Rambler Cottage
Shripney Lane
Bognor Regis
West Sussex
PO22 9NR

Planning application BE/151/11

SHRIPNEY GARDEN CARAVAN PARK, SHRIPNEY LANE, SHRIPNEY
Proposals 01
Nov 2011

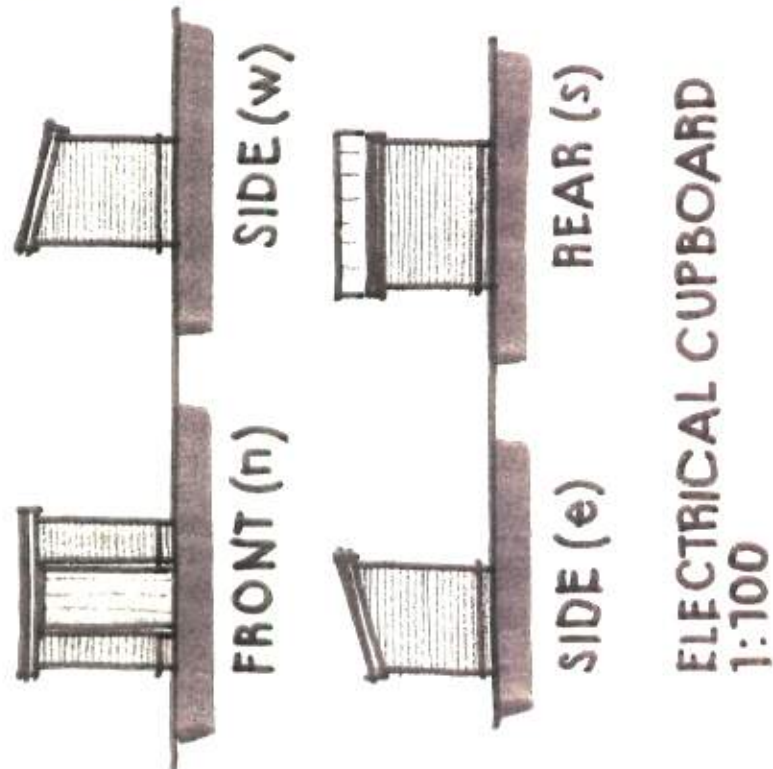
1. The application states that there are no trees or hedges adjacent to the site that might be important as part of the local character. This is untrue. The whole length of the boundary to the south is a conservation area with a range of mixed trees and hedges. The new siting of the caravans encroaches significantly on this vegetation.

3. PDAS section 1.03 is, I am afraid totally untrue. I have submitted a composite of the original application plan and the new one. The new one shows the base to be significantly (approximately 4 metres) closer to the conservation area than the original. How is it that Henry Adams is so incompetent? Or is this simply a way to mask the actual development?

4. PDAS section 1.04 – 1.06. The report suggests the new siting of the caravan pads on the northern side of the site was to accommodate the car park (although the car park is almost exactly the same as originally proposed) and the two trees. The report fails to recognise that a number of trees have previously been felled
